**89 John Whiteway Drive, Gosford**

Submitted to Department of Planning and  
Environment

11 February 2022 | 2190460

DRAWING TITLE  
BASEMENT

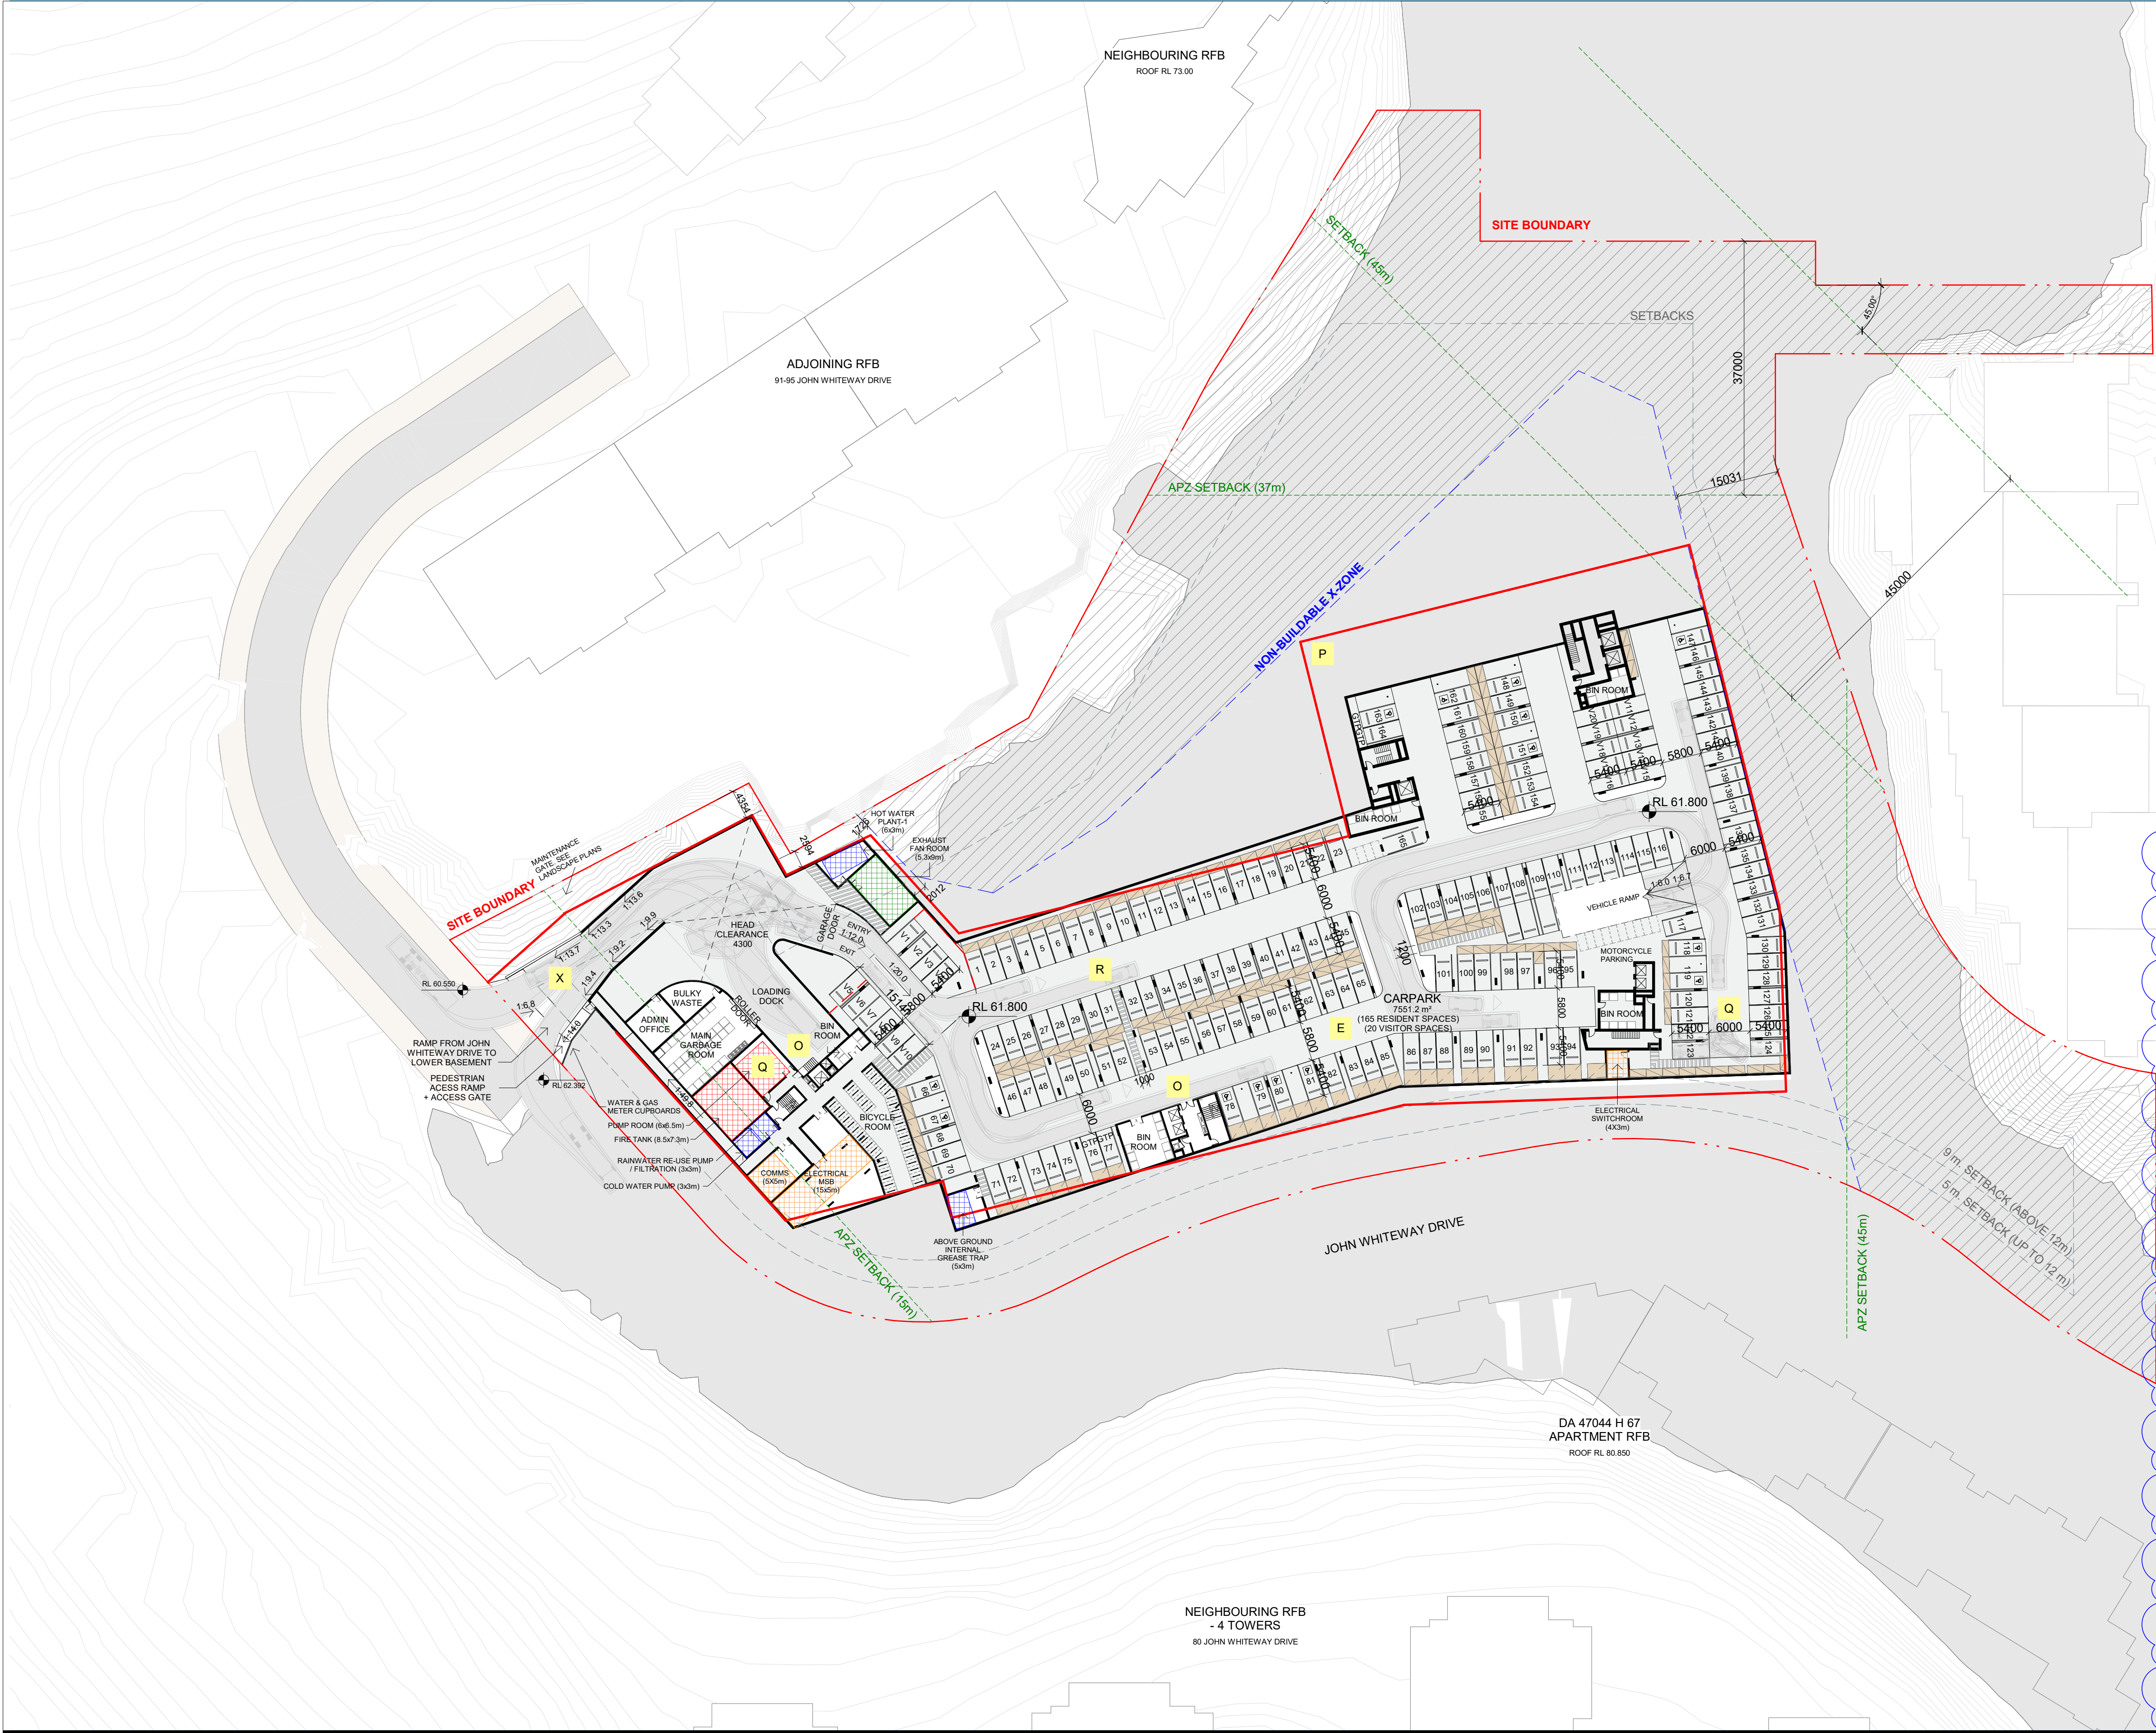
DPE have identified an error in calculating the parking requirements for the proposed neighbourhood shop, resulting in one less spot proposed than what is required. Accordingly, they have requested this error be amended.

DPE have also considered the location of spaces designated to the neighbourhood shop to be impractical and recommends them to be relocated.

Since exhibition the layout of the car park has been refined to include an additional (1) car parking space for the neighbourhood shop to comply with the parking rate under the DCP (4 total).

One additional car space for the neighbourhood shop has been added (to 4 spaces total) to the design. The 4 parking spaces have been allocated as follows:

- 2 x spaces within the secure parking area for staff (as the shop may have a maximum 2 staff and who will have security access)
- 2 x spaces provided in the porte cochere which is publicly accessible during business hours
